EG/107/17/DOC

Proposal: Application for approval of details reserved by condition imposed under planning application EG/38/15/PL relating to condition No. 3 - Surface water drainage.

Site: 97 Barnham Road, Eastergate, PO22 0EQ.
EG/107/17/DOC

Number
S17-03-01 E

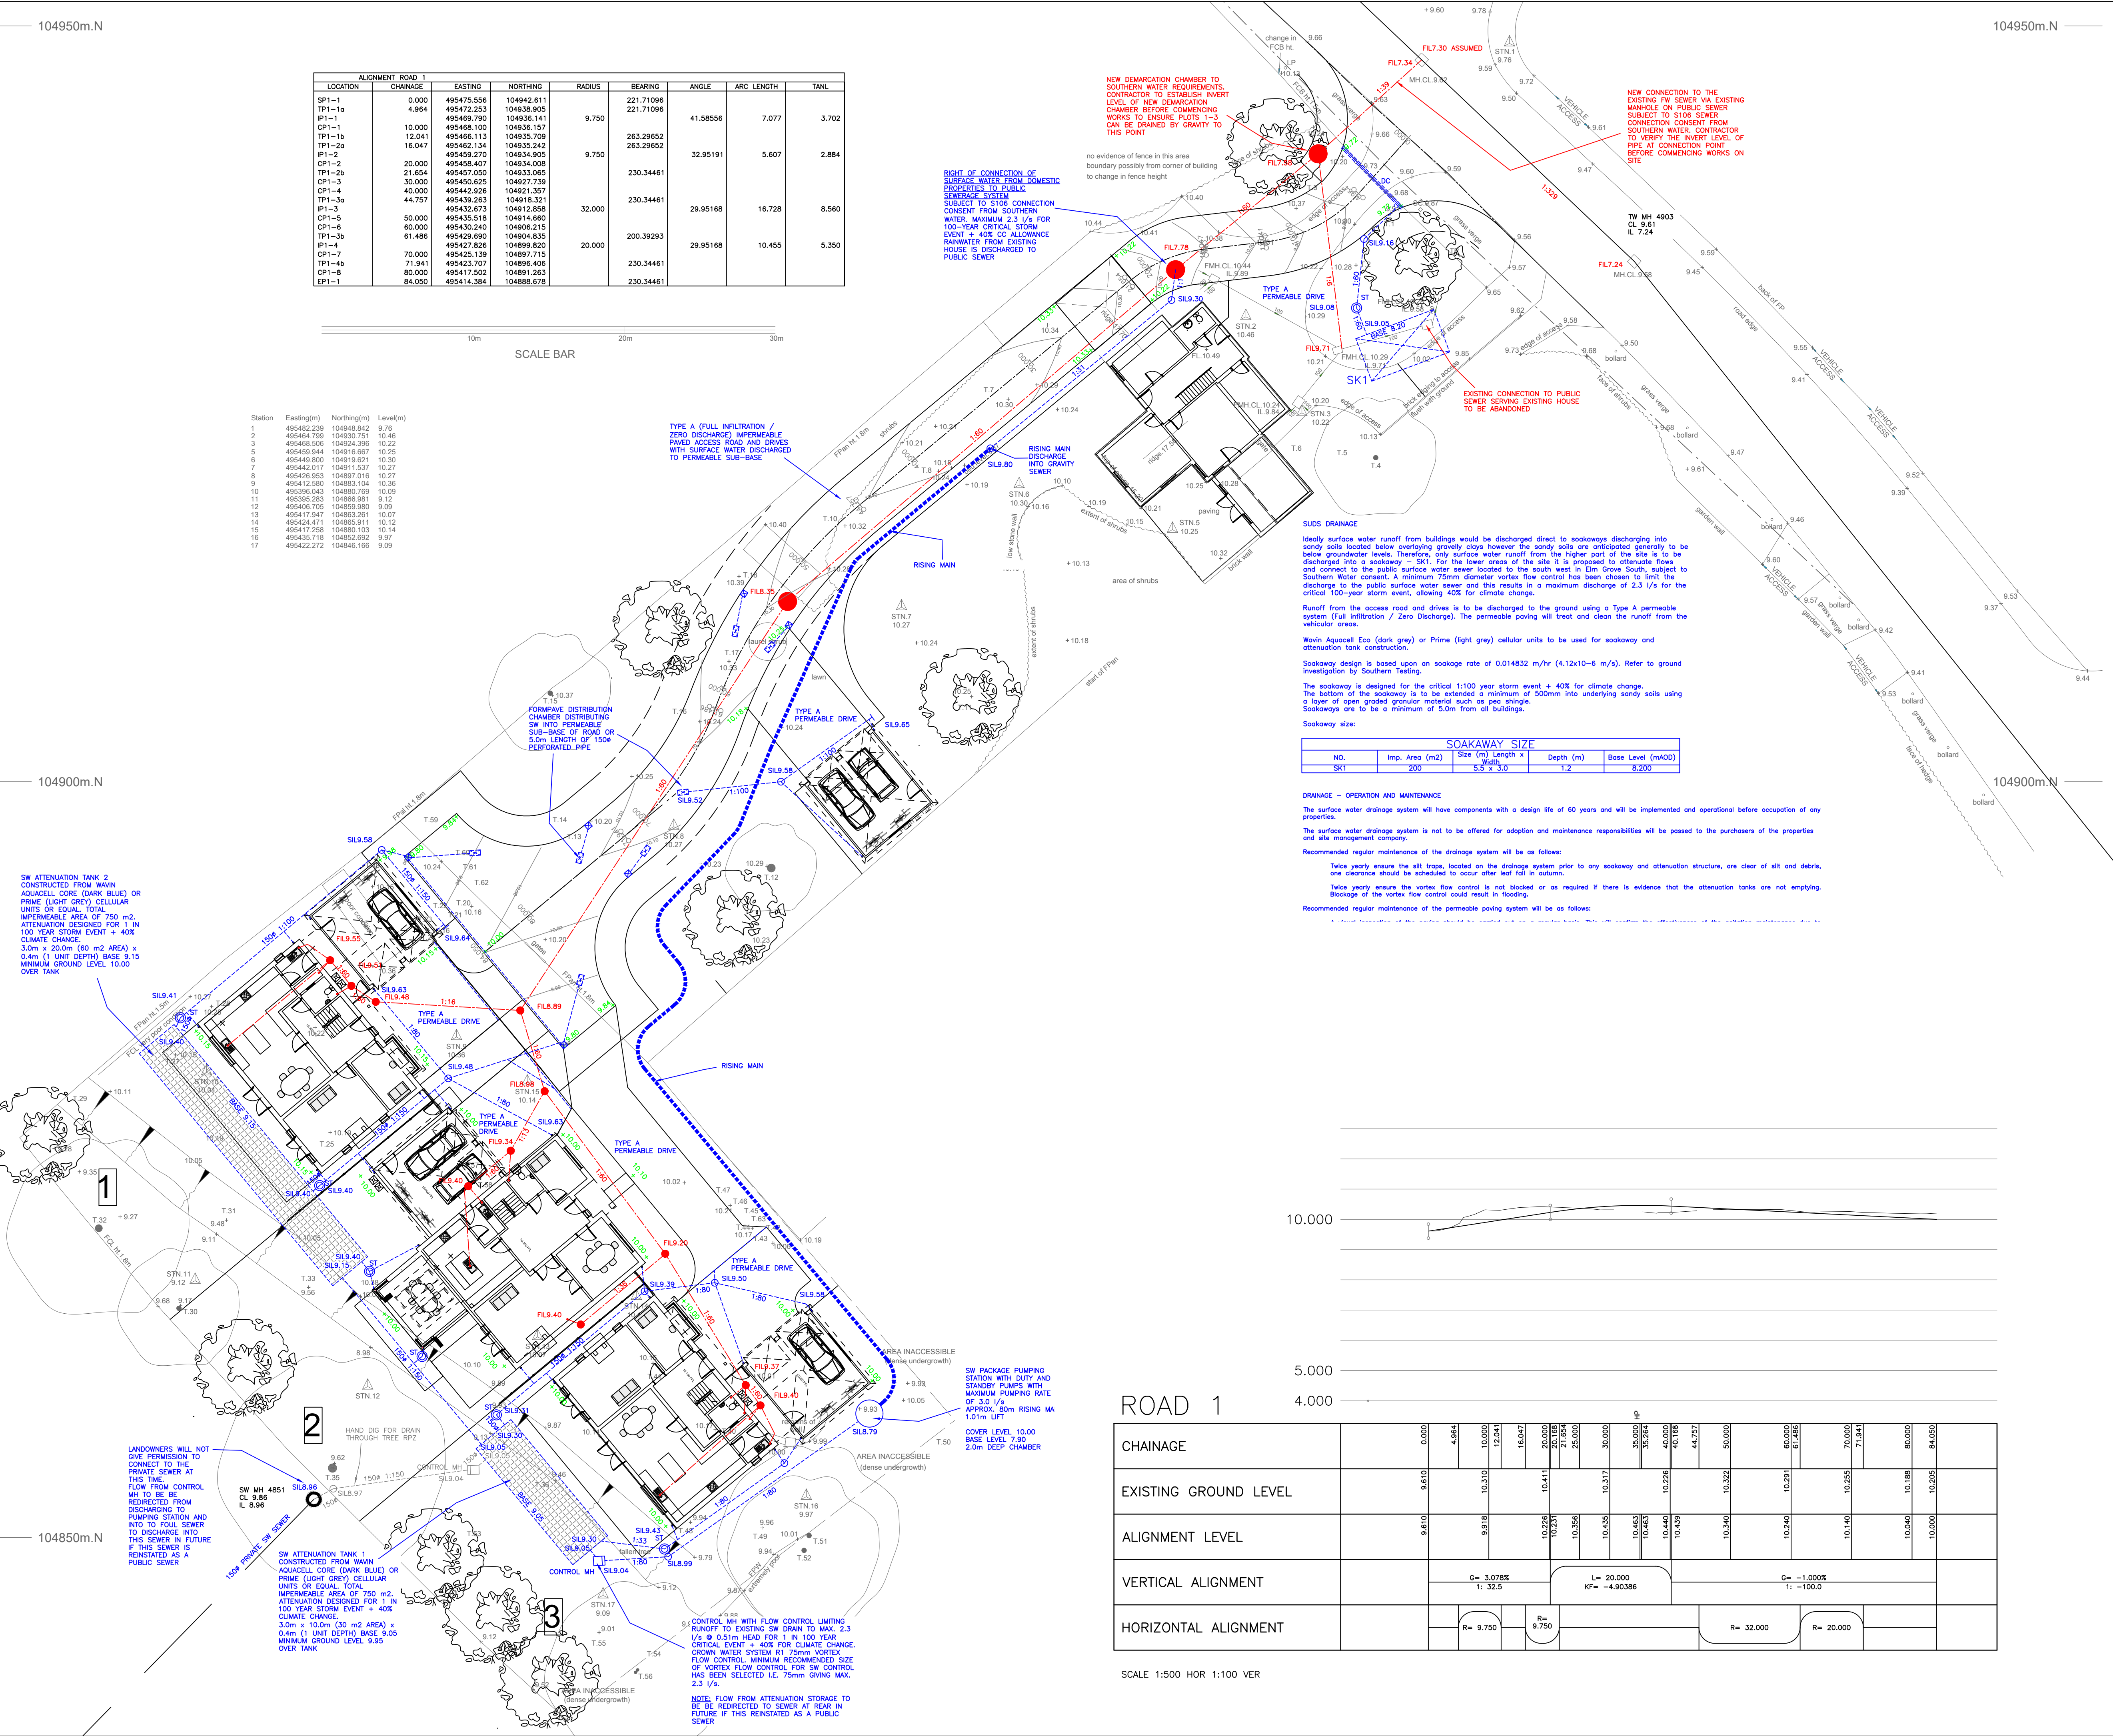
Southern Water cannot recommend discharge of condition relating to surface water drainage as the surface water connection point shown in submitted drainage layout (S17-03-01 E) is different from that as shown in Section 106 connection approval.

Also, proposed connection of surface water into foul sewer is not acceptable to Southern Water.

Please note that the surface water should not mix with the foul sewer, there are dedicated foul and surface water sewer system in the vicinity of the site. Southern Water would prefer that onsite foul and surface water discharges to the dedicated public sewer system. No surface water should be permitted to be discharged to the foul sewerage system, in order to protect properties downstream from flooding.
